Application no: H09/0643/00

Description: Alter existing outbuilding to
provide further residential
accommodation.

Location: Chestnut House South
Penny Hill
Holbeach

Amendment: Amended Design
Dwg no. 200821A

Written dimensions to be used in preference to scaled and all measurements to be verified by checking on site.	Scale 1:50
Local Authority Ref. Planning H03/0643/00 Building Regulations	Drawing No. 200821 A Date August 2000

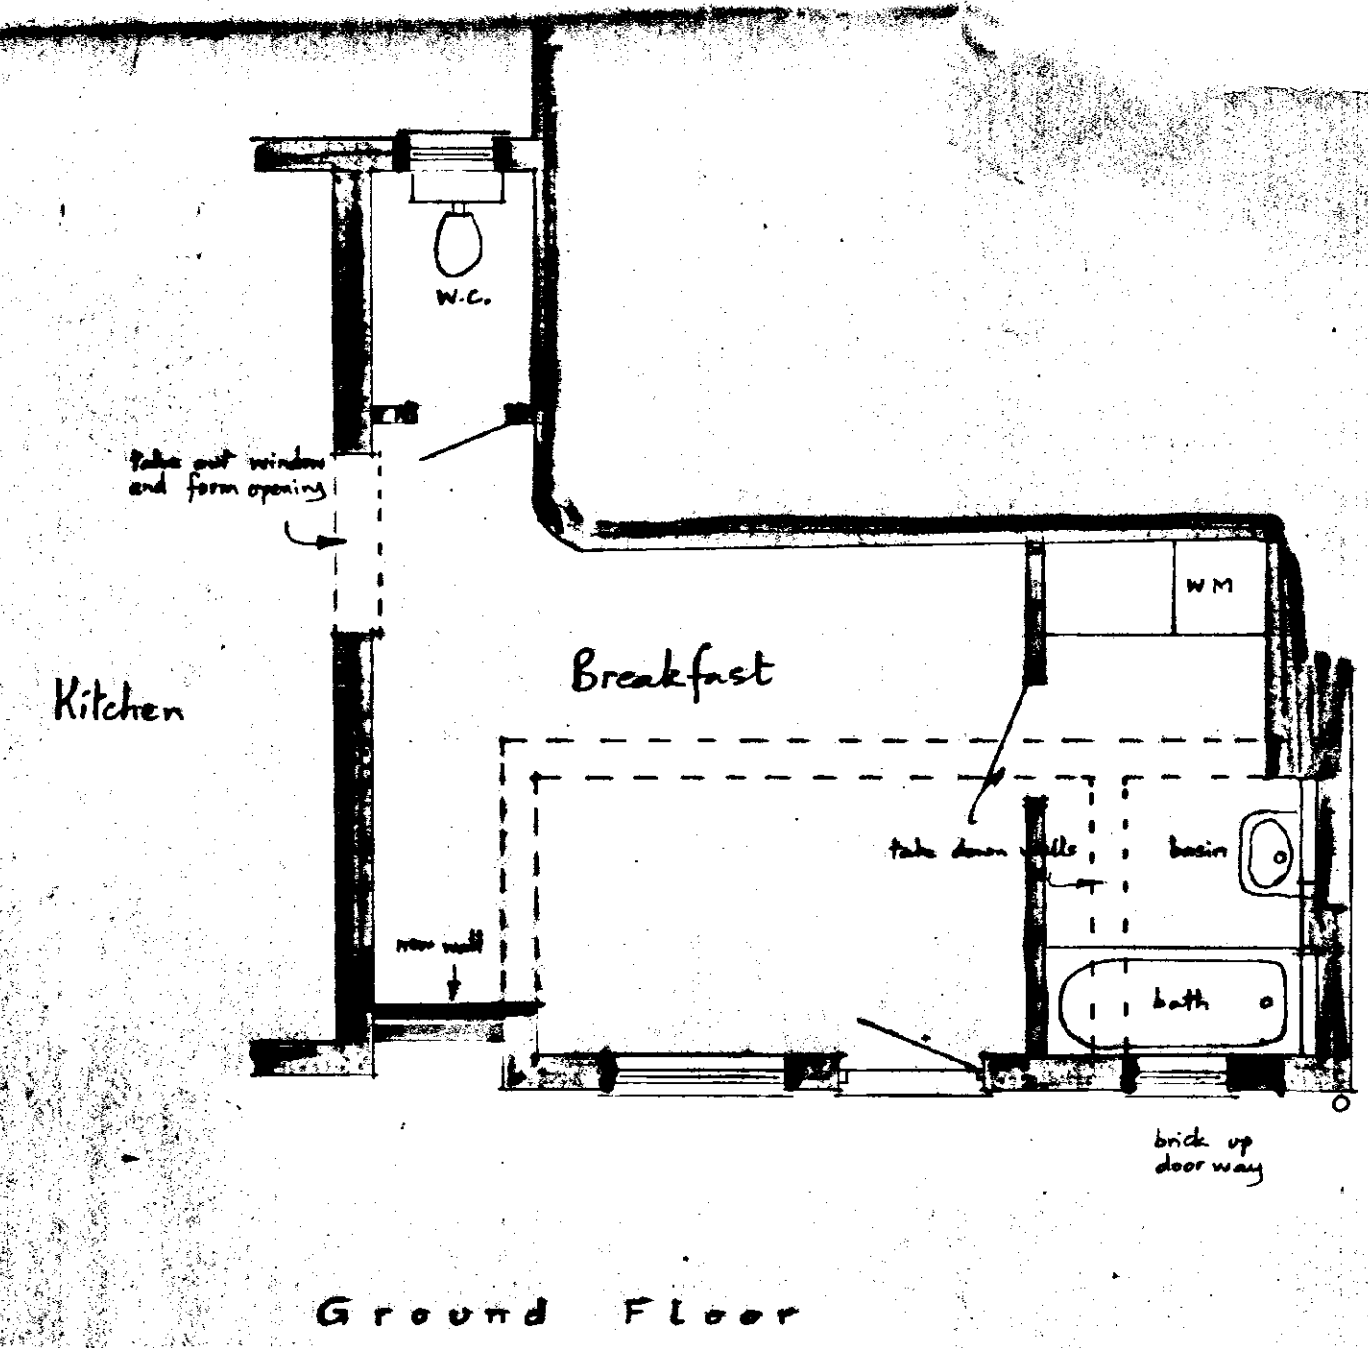
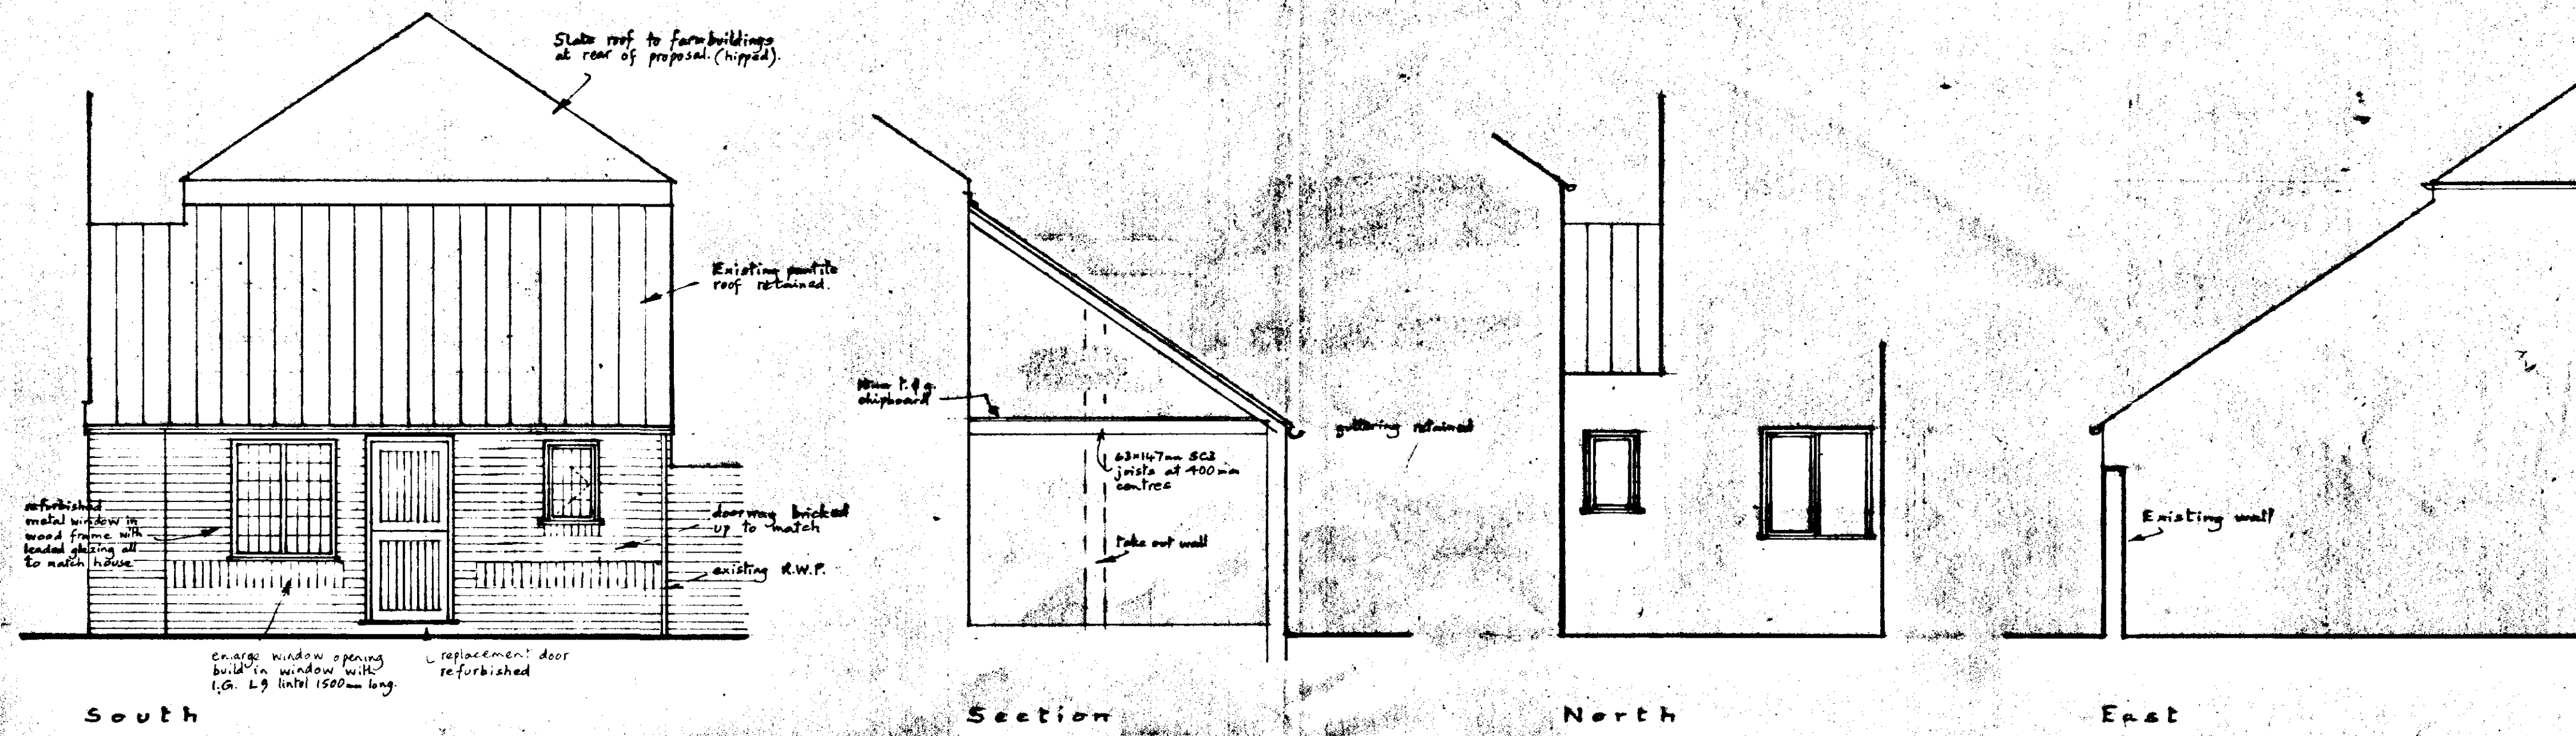
Following the visit of Mr D. ^{Gedney}~~Roberts~~, I enclose two copies of the amended plans showing the revisions and work as carried out on site

Mr. and Mrs. Byford Chestnut House South, Penny Hill, HOLBEACH.	
Written dimensions to be used in preference to scaled, and all measurements to be verified by checking on site.	Scale 1:50
Local Authority Ref. Planning N09/0643/00 Building Regulations	Drawing No. 200B21 A/C Date August 2000

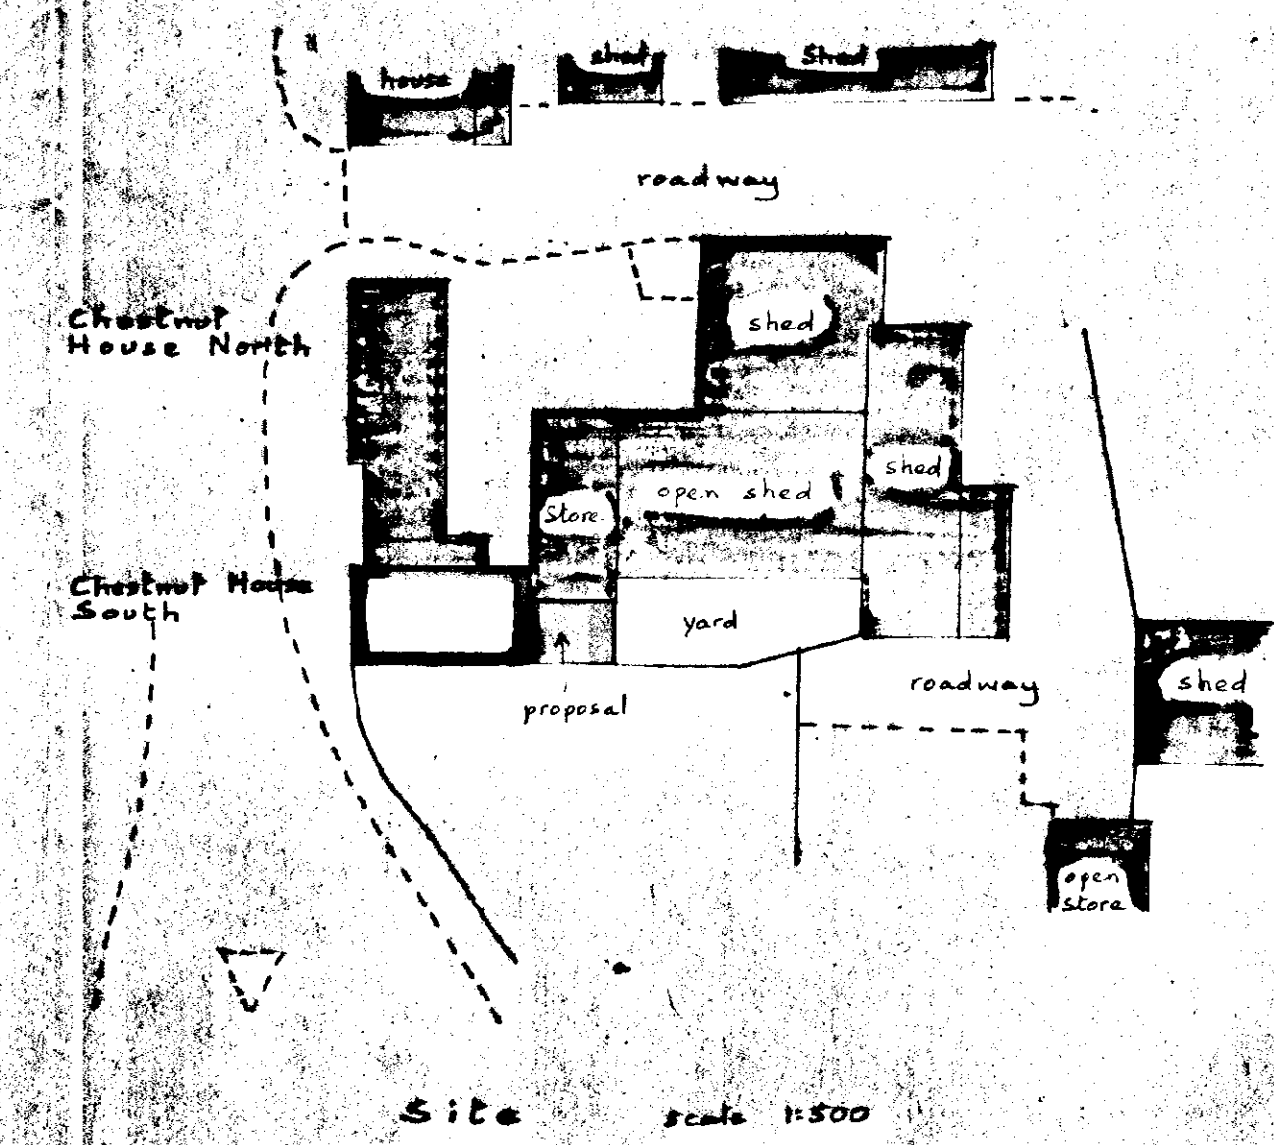
*omit dormers
 alter window (to Bathroom)
 alter door (to dining)
 update plan
 add north and east elevations*
